December 23rd, 2013

Project Name: Munjoy Heights
Six new buildings comprising 29 residential townhouses; one existing house on reconfigured lot

Project ID: 2013-228

Project Address: 79 Walnut Street

DRAWING NO.
SN-1

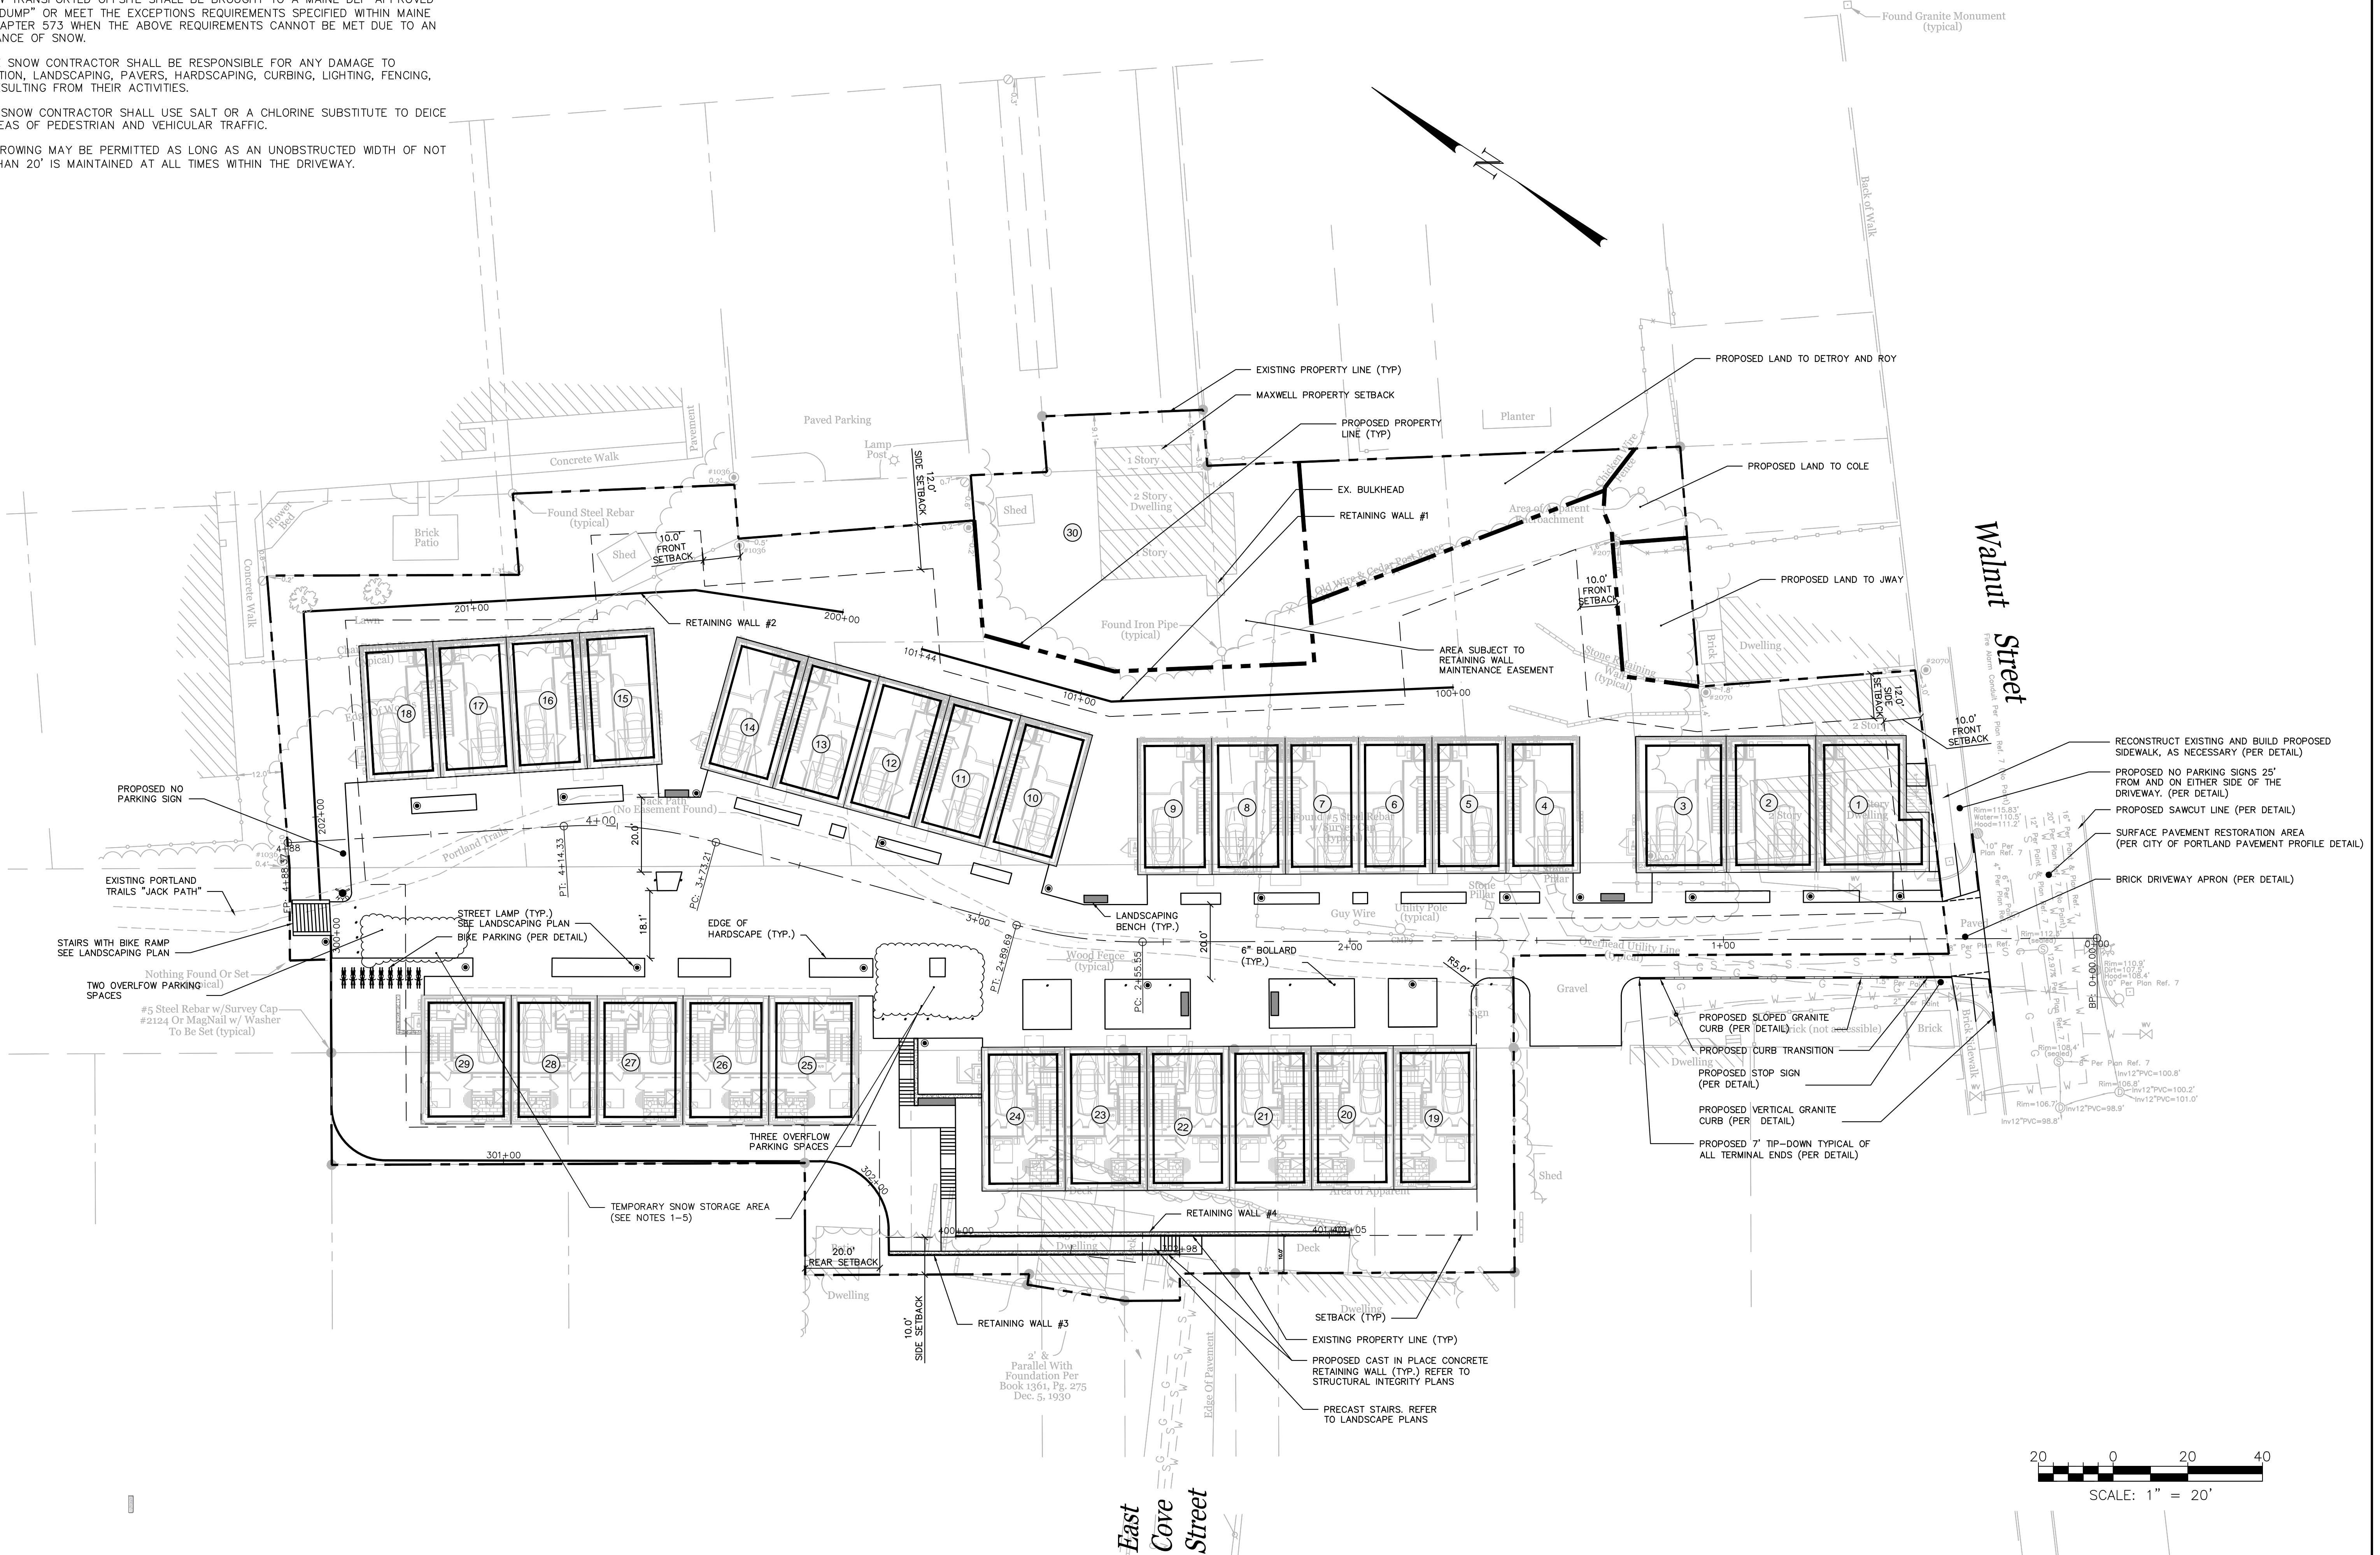
- That the minimum vehicle access of 20 feet is maintained at all times by adequate snow removal in accordance with the approved Snow Storage Plan (Plan 21 to this Report) and a specific prohibition on parking in front of the garages for Units 1-11 due to encroachment into the 20 foot circulation area required by the fire Department.

- * **Vehicles shall be prohibited from parking in front of garages for units 1 through 11 due to encroachment into the 20-foot circulation required by the Fire Department. I will leave it to other City staff to best determine how to ensure this restriction is noted.**
